CITY OF ALBUQUERQUE

May 23, 2024

**Re: Cuba Botanicals LLC Grow Facility
5904 Florence NE, Albuquerque, NM 87113
Traffic Circulation Layout
Engineer's/Architect's Stamp 5/22/2024 (B18D030)**

Clear Sight Triangle at main Entrance: Florence Ave.

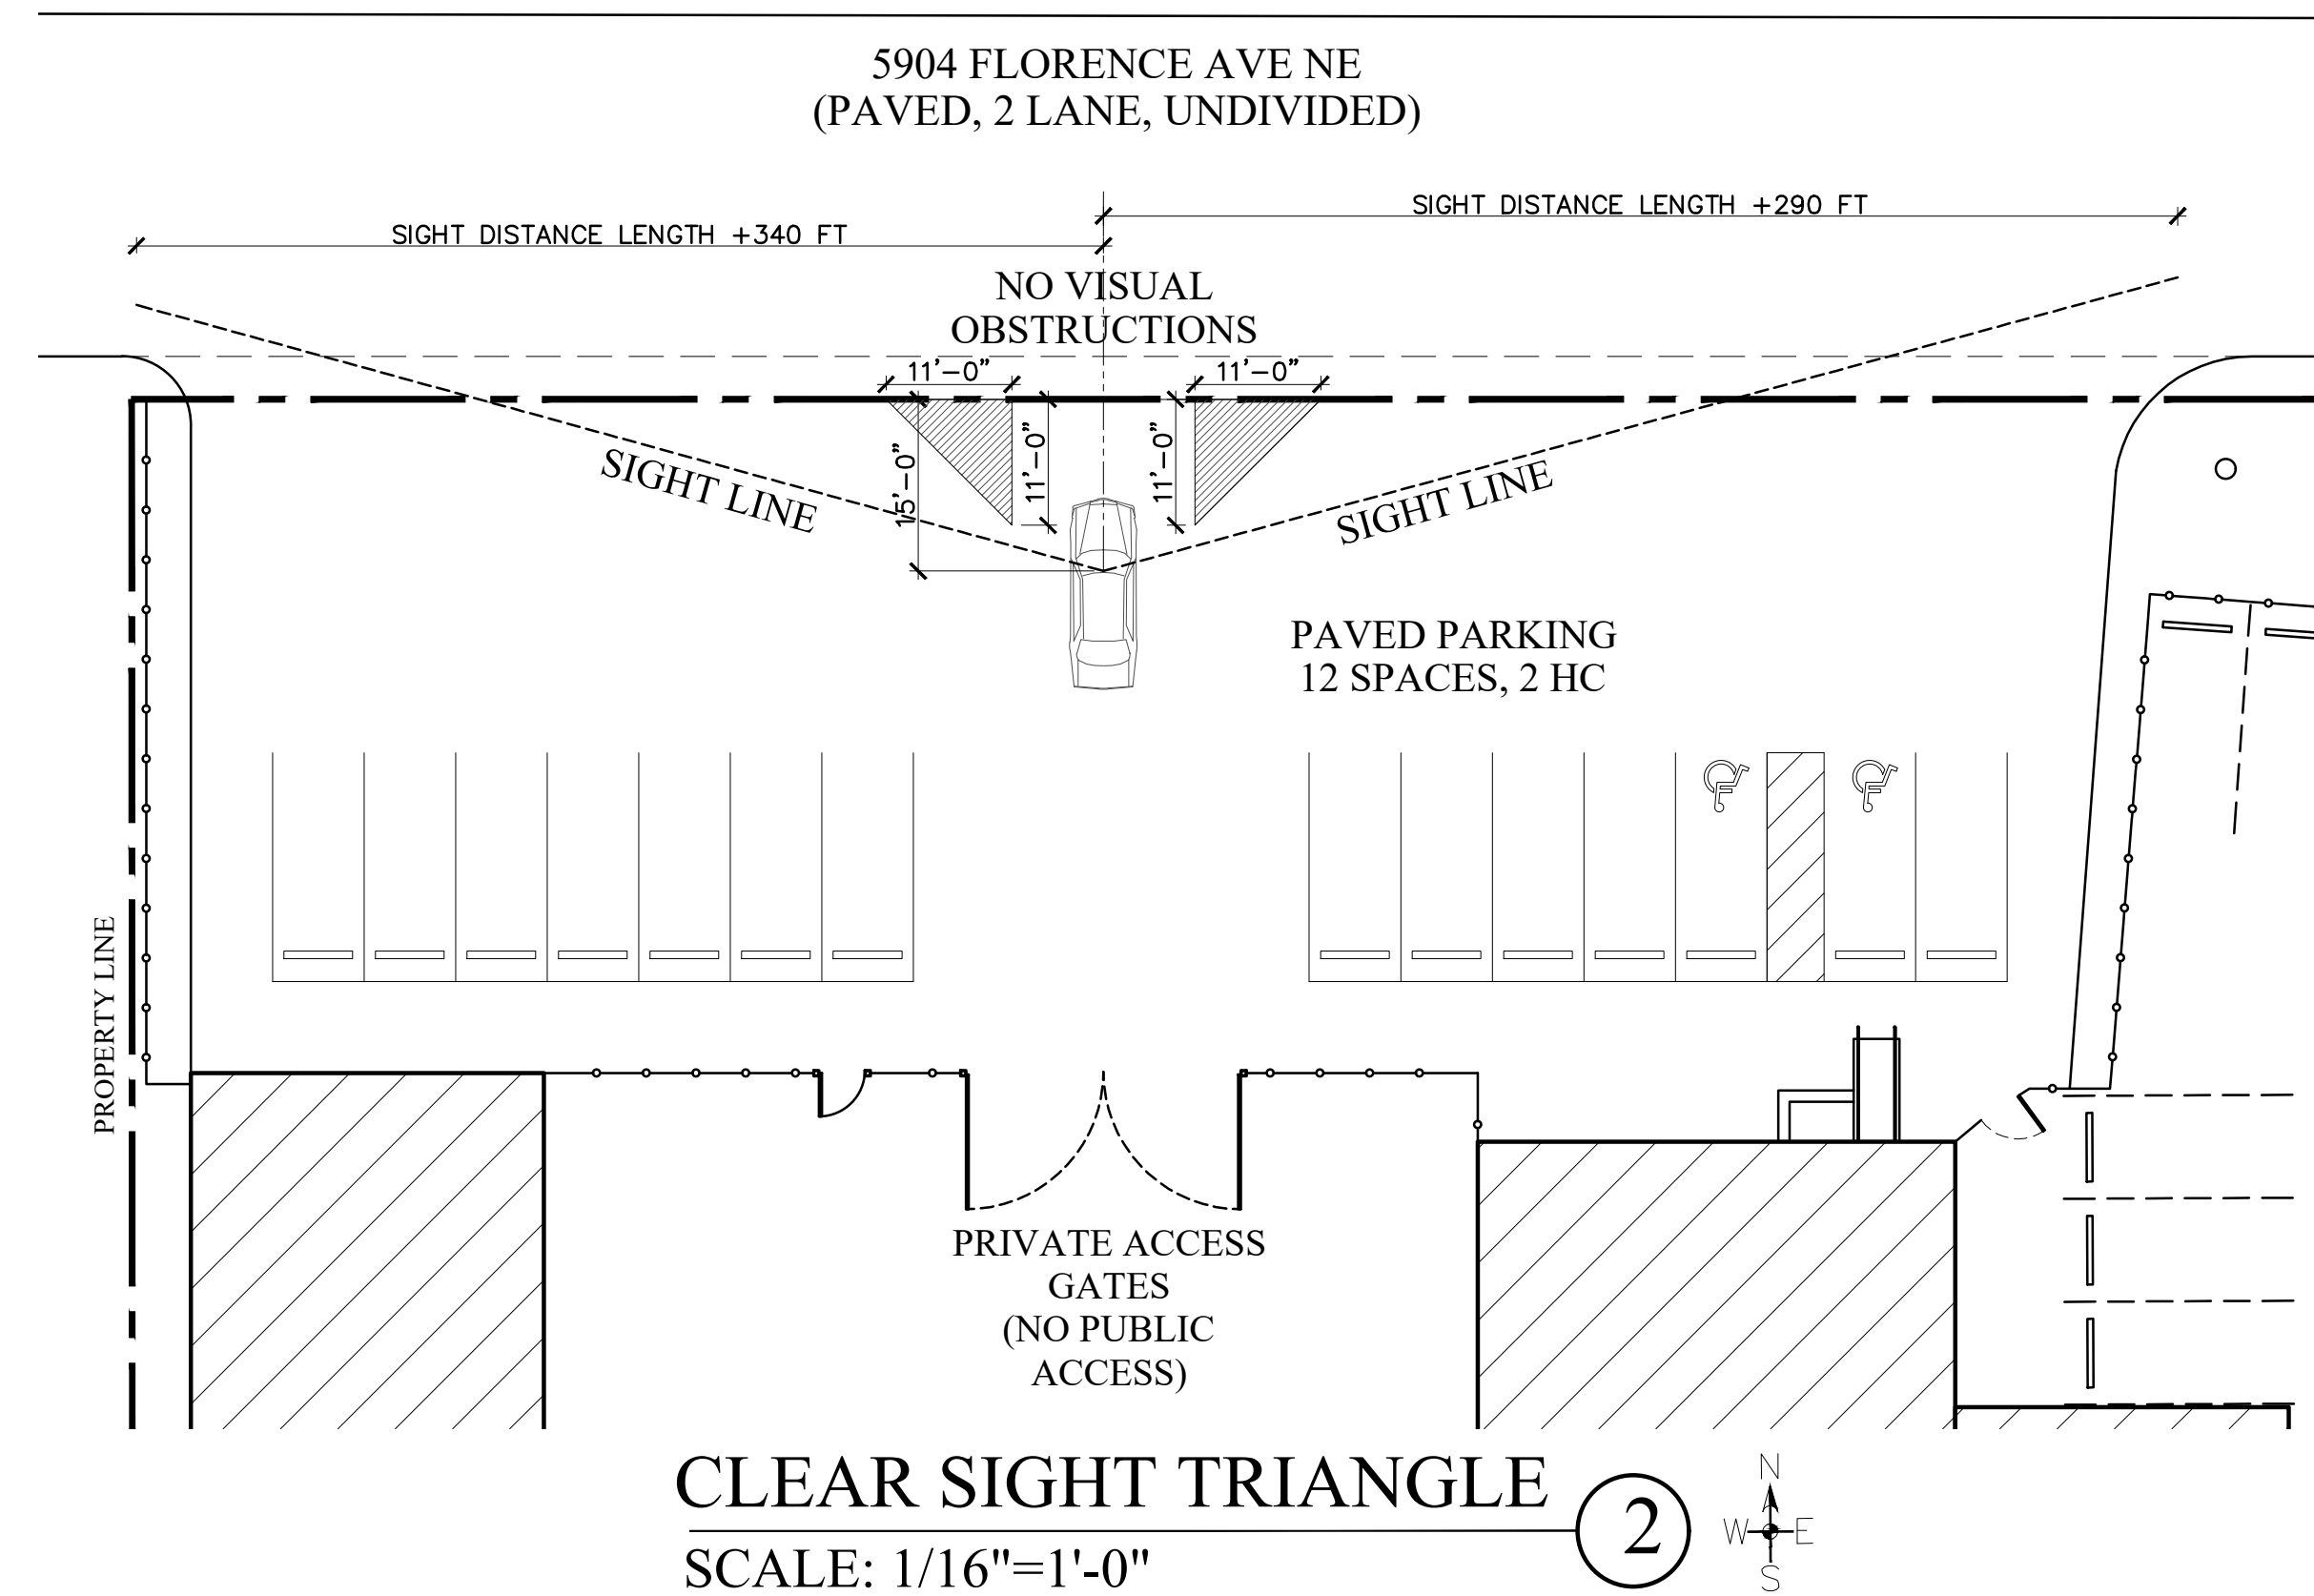
3. All accessways to the site from the adjacent roadway shall be ADA-compliant. Gravel path is not acceptable.
4. Show the dimensions of the existing H.C. parking, this should be for van parking with 8 ft wide van access aisle

6. Show all drive aisle widths and radii.
7. The minimum drive aisle dimensions are shown below

Minimum Drive Aisle Width
Two Way Traffic	22'
Main Circulation Road	24'
Fire Lane	20'

8. Per DPM, a 6 ft. wide ADA accessible pedestrian pathway is required from the ADA parking stall access aisles to the building entrances. Please clearly show this pathway and provide details.
9. Curbing should be installed to delineate landscape, parking, and pedestrian ways and identify points of access. Please call out detail and location of barrier curb.
10. Refuse vehicle maneuvering shall be contained on-site. The refuse vehicle shall not back into the public right of way.; provide a copy of refuse approval.
11. All one-way drives shall have "One Way" and "Do Not Enter" signage and pavement markings. Please show detail and location of posted signs and striping.
12. If you are using Florence Ave as your entrance, you need an access easement from the owner of the property to your north and install sidewalk along Florence.
